City of Portland, Maine - Building or Use Permit Application
 389 Congress Street, 04101 Tel: (207) 874-8703, Fax: (207) 874-8716

Permit No: 02-1118	Issue Date: OCT 6 2002	CBL: 116 C026001
-----------------------	---------------------------	---------------------

Location of Construction: 54 Pitt St	Owner Name: Yue Wai Kuen	Owner Address: 54 Pitt St	Phone: 207-409-6446
Business Name: n/a	Contractor Name: Gregoire, Paul	Contractor Address: 571 Ferry Road Saco	Phone: 2072846549
Lessee/Buyer's Name n/a	Phone: n/a	Permit Type: Additions - Duplex	Zone: R-5

Past Use: Duplex	Proposed Use: Duplex / Replace 16' x 26' Deck and add egress stairs from upper level.	Permit Fee: \$142.00	Cost of Work: \$16,342.00	CEO District: 2
<p><i>Legal - 2 DU:</i></p> <p><i>No increase in units allowed</i></p>		FIRE DEPT: <input type="checkbox"/> Approved <input type="checkbox"/> Denied	INSPECTION: Use Group: <i>R-3</i> Type: <i>SB</i> <i>10/10/02</i>

New Deck

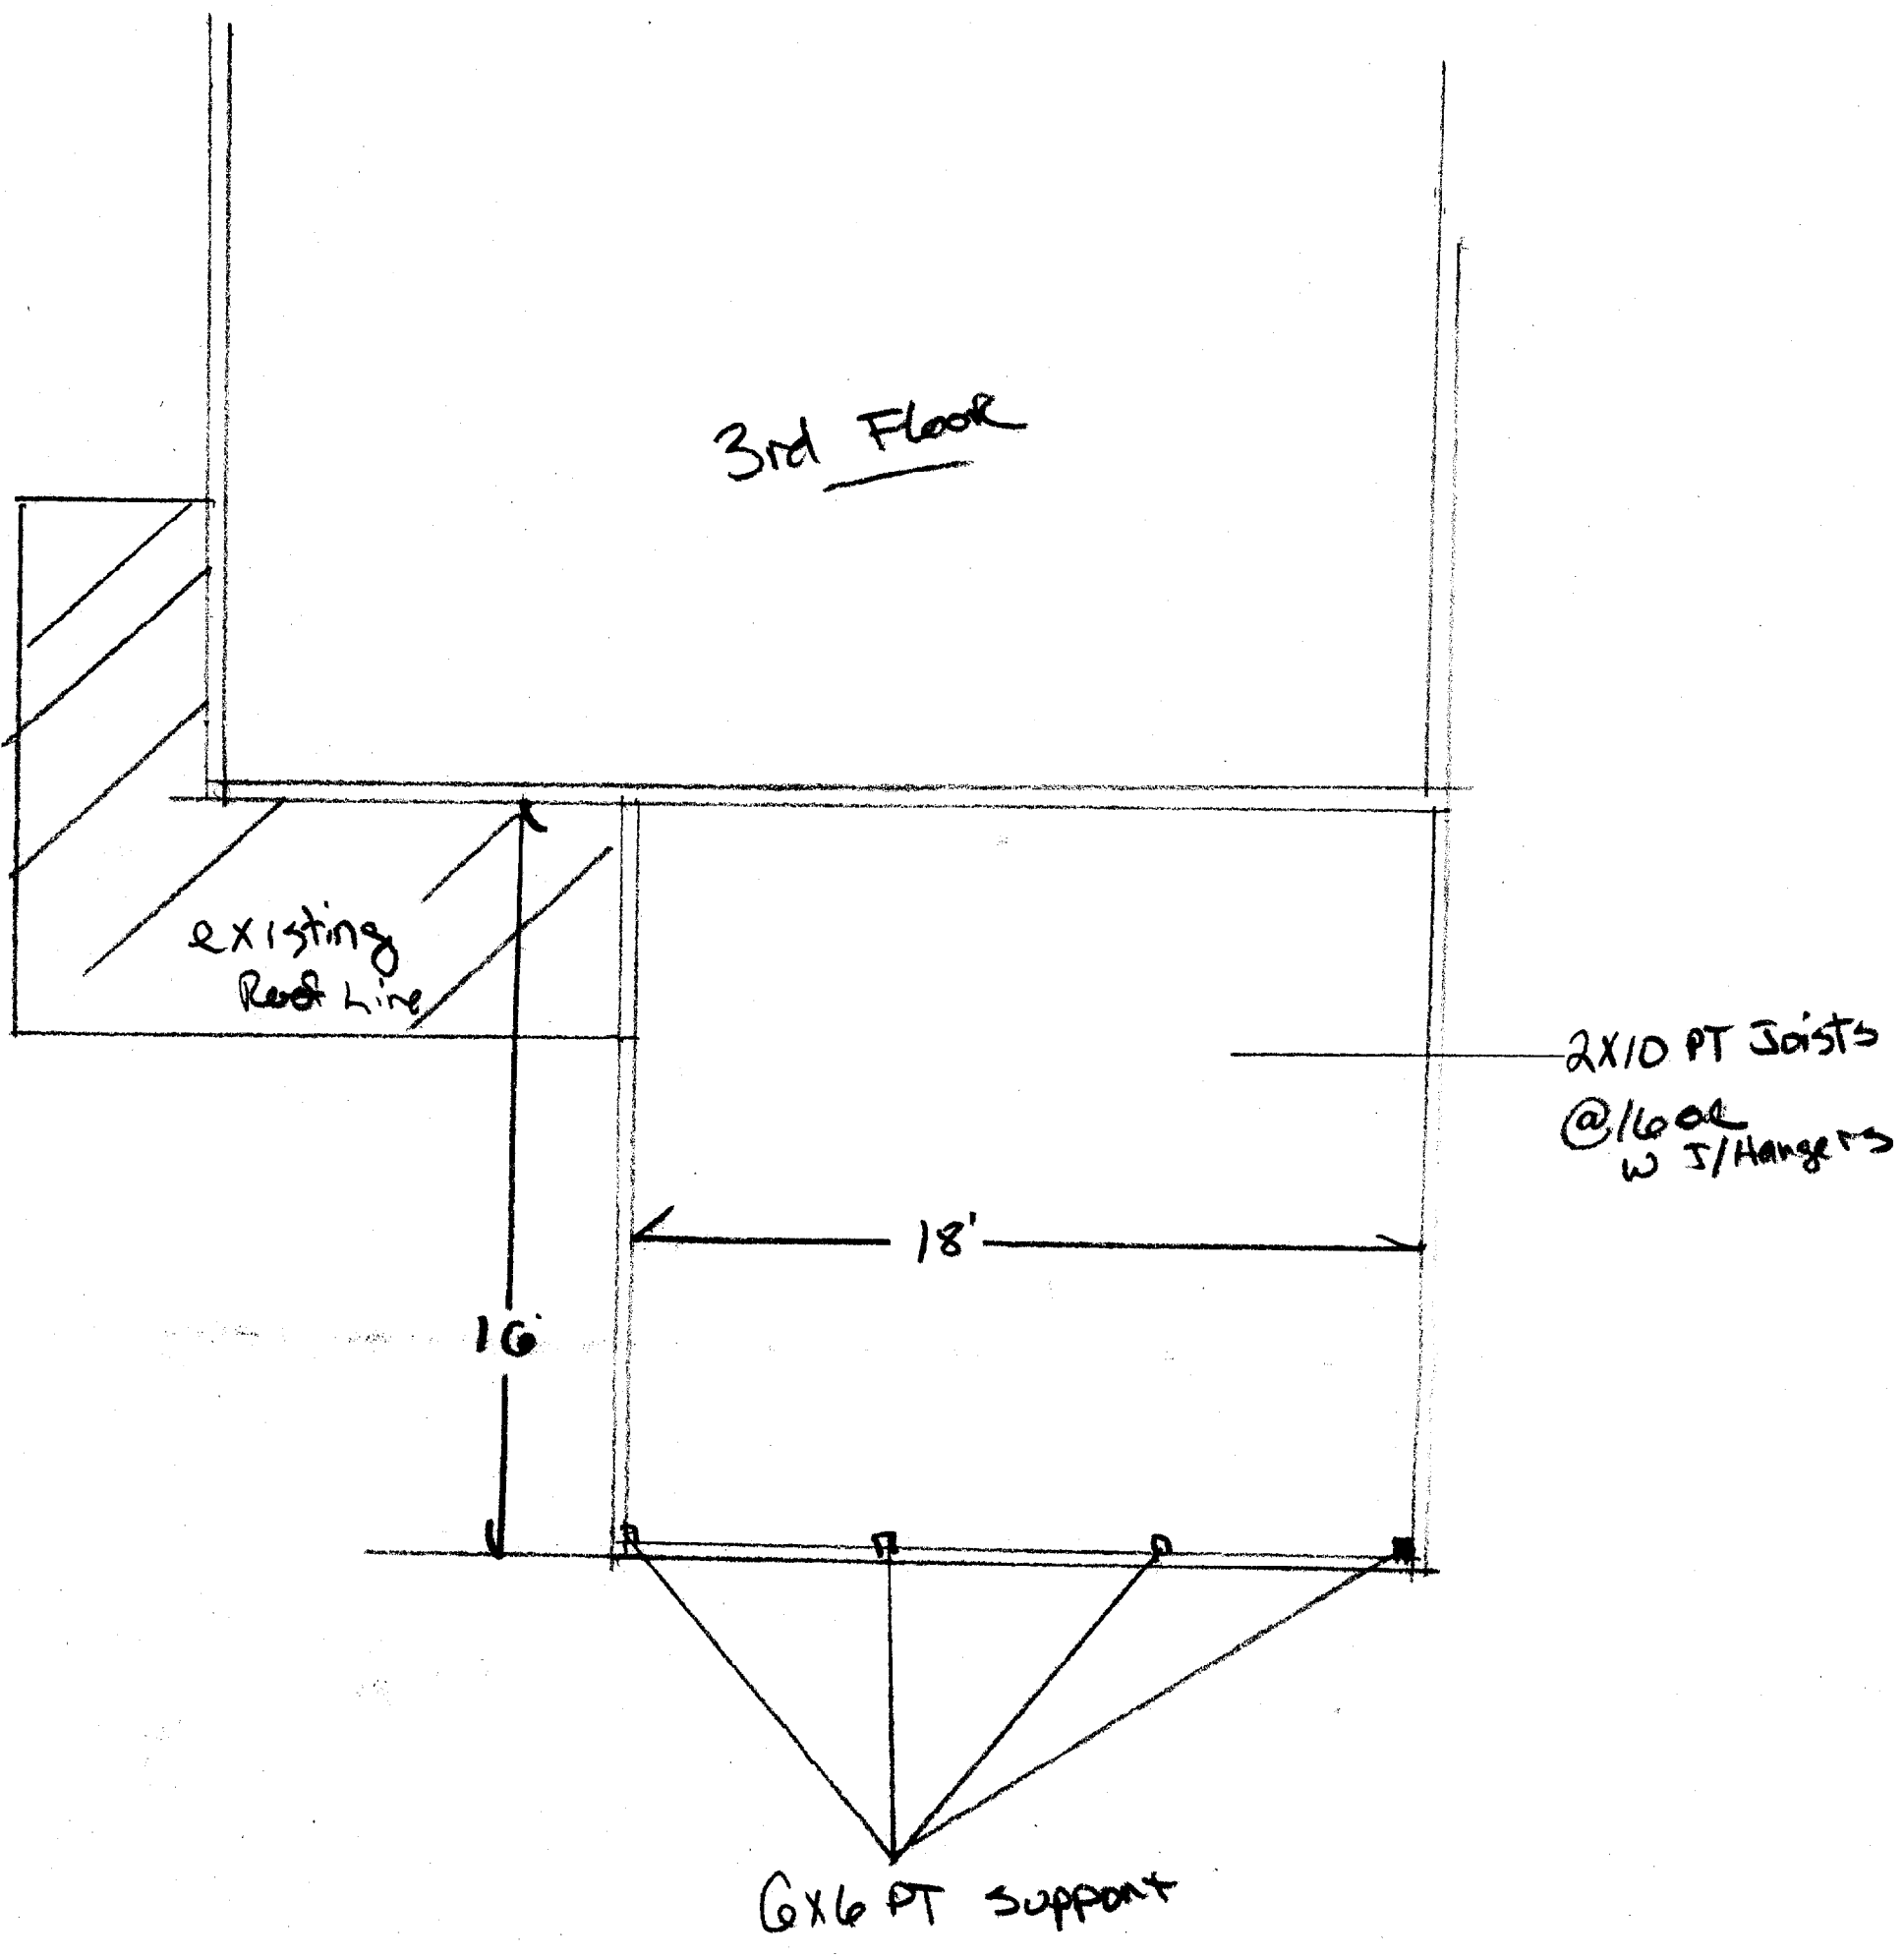
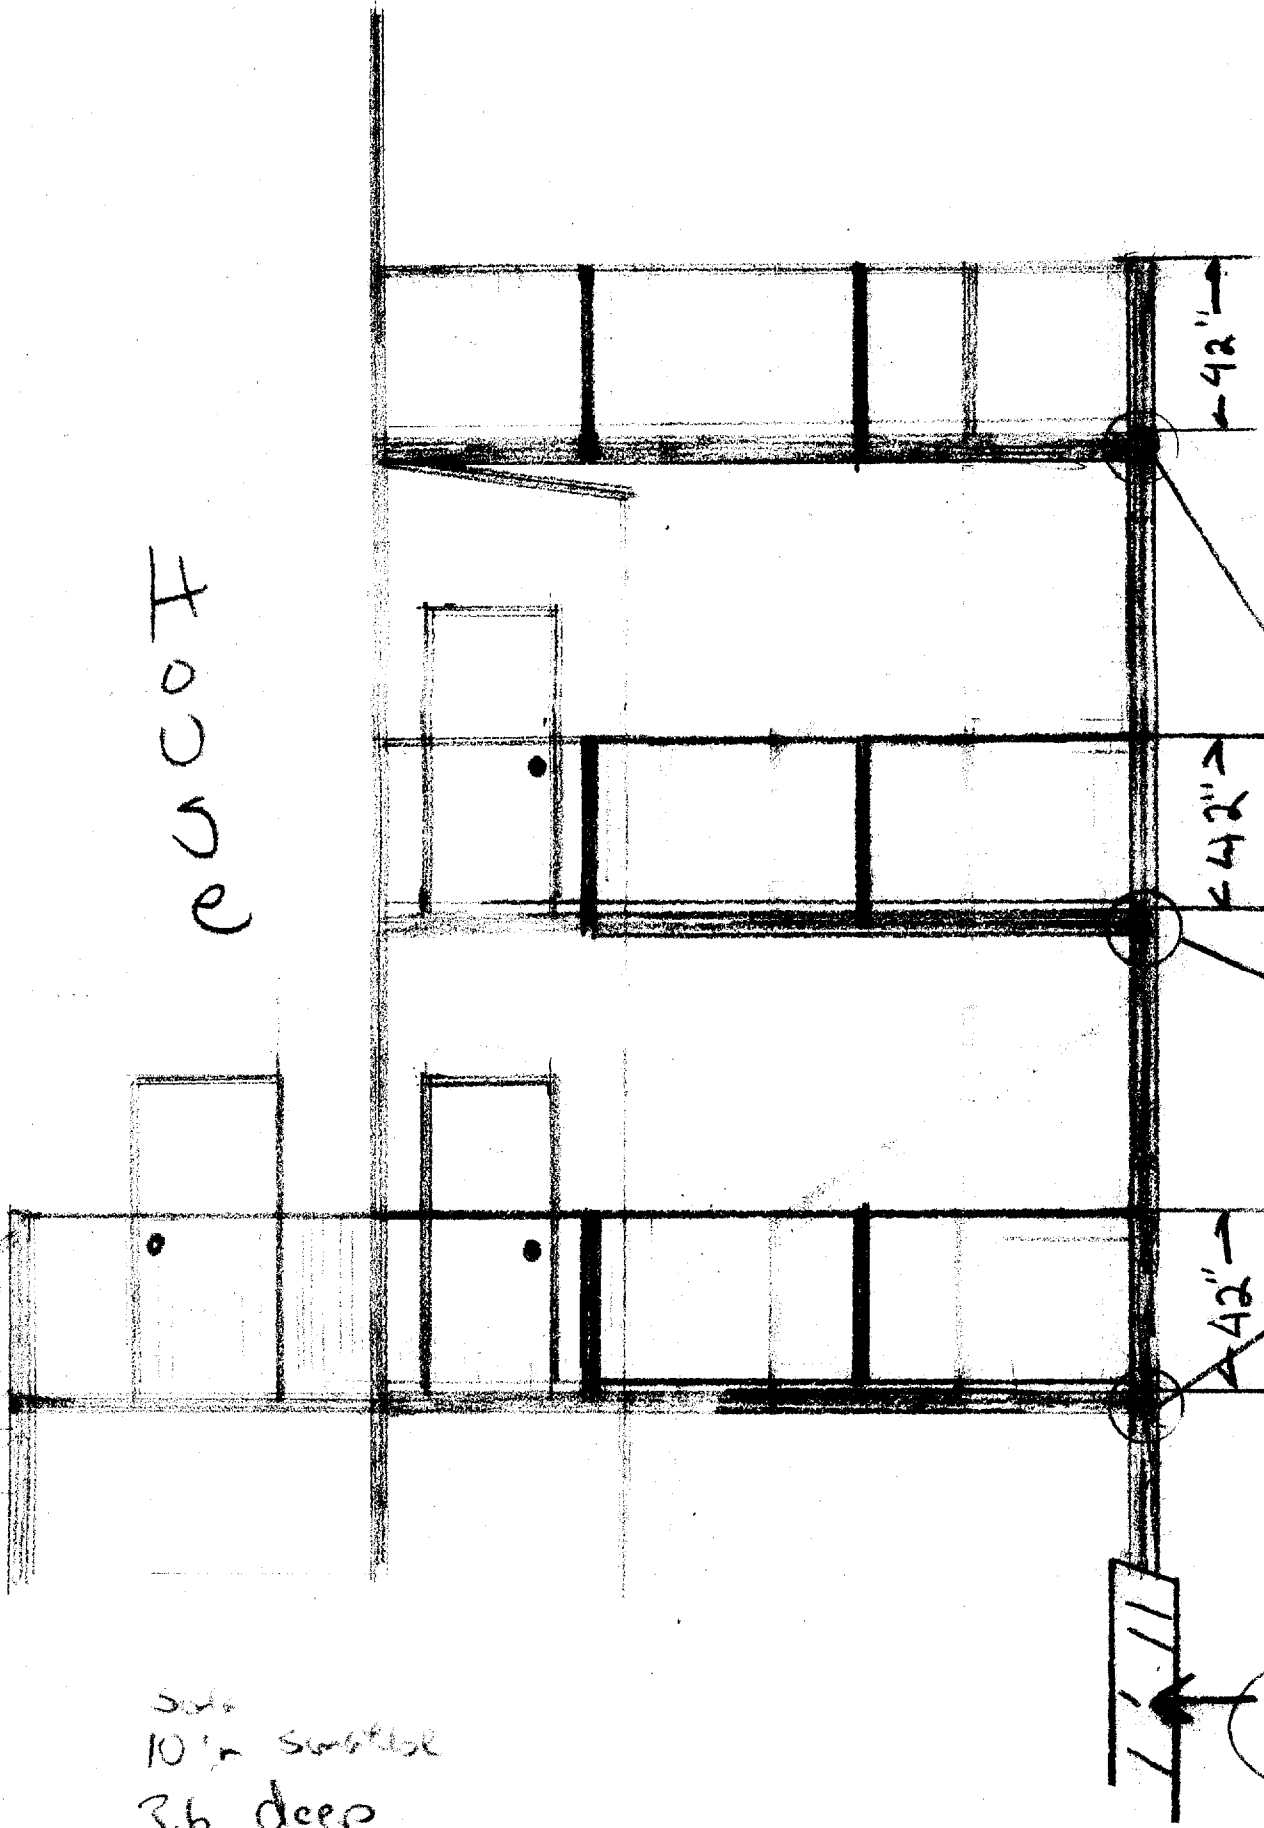
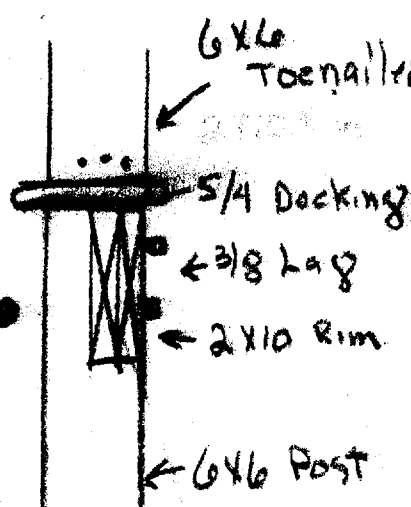
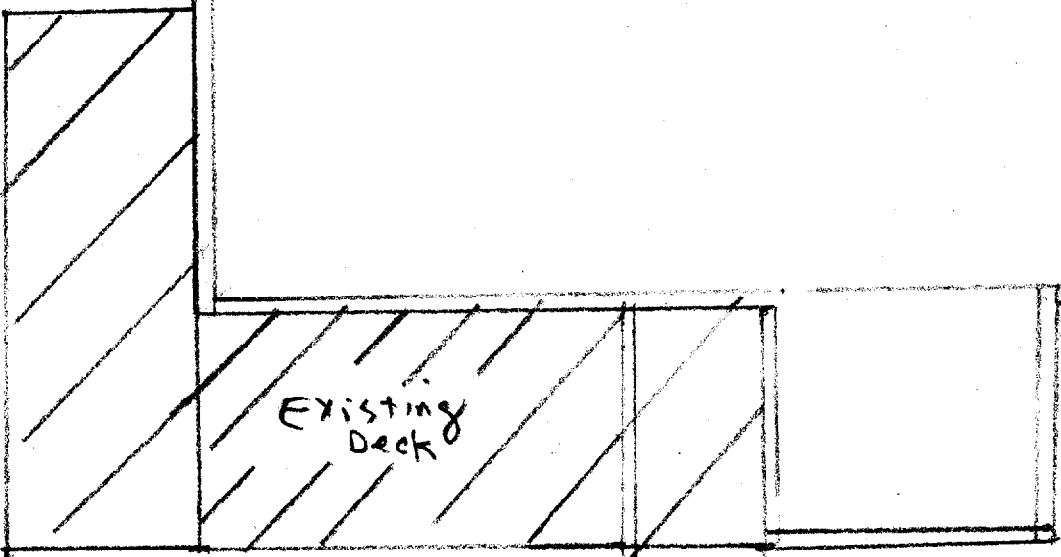
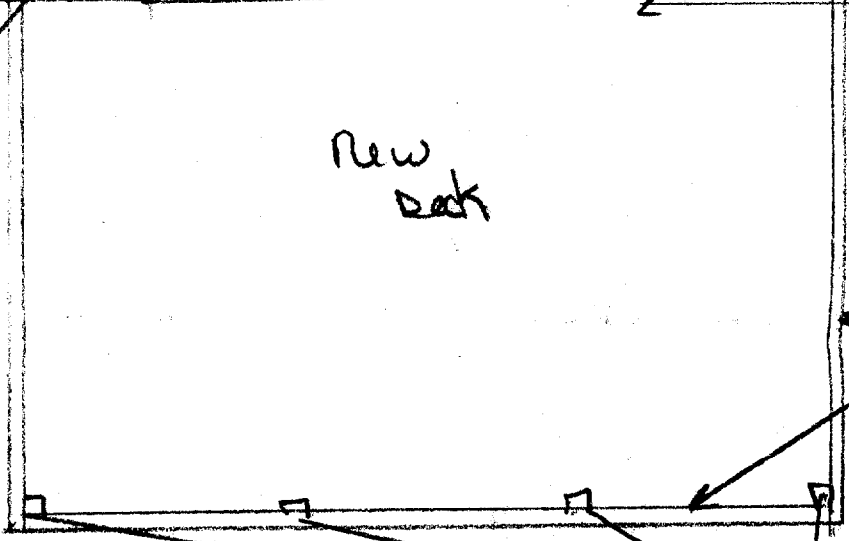
Comments: **54 Pitt St -10//09/2002 - left message with contractor - adding an open, exterior stairway above the ground floor which is not allowed - also expanding deck larger than what the assessors are showing for what is there. 10/10/02 contractor talked with Mike - took all plans back**

Framing members must be 2" x 12" due to 16' span, this carry's over to ledgers and carriers.
Foundation tubes must be 48 inches in depth.
Openings in guards must be less than 4 inches / NO LADDER in the ornamental pattern.
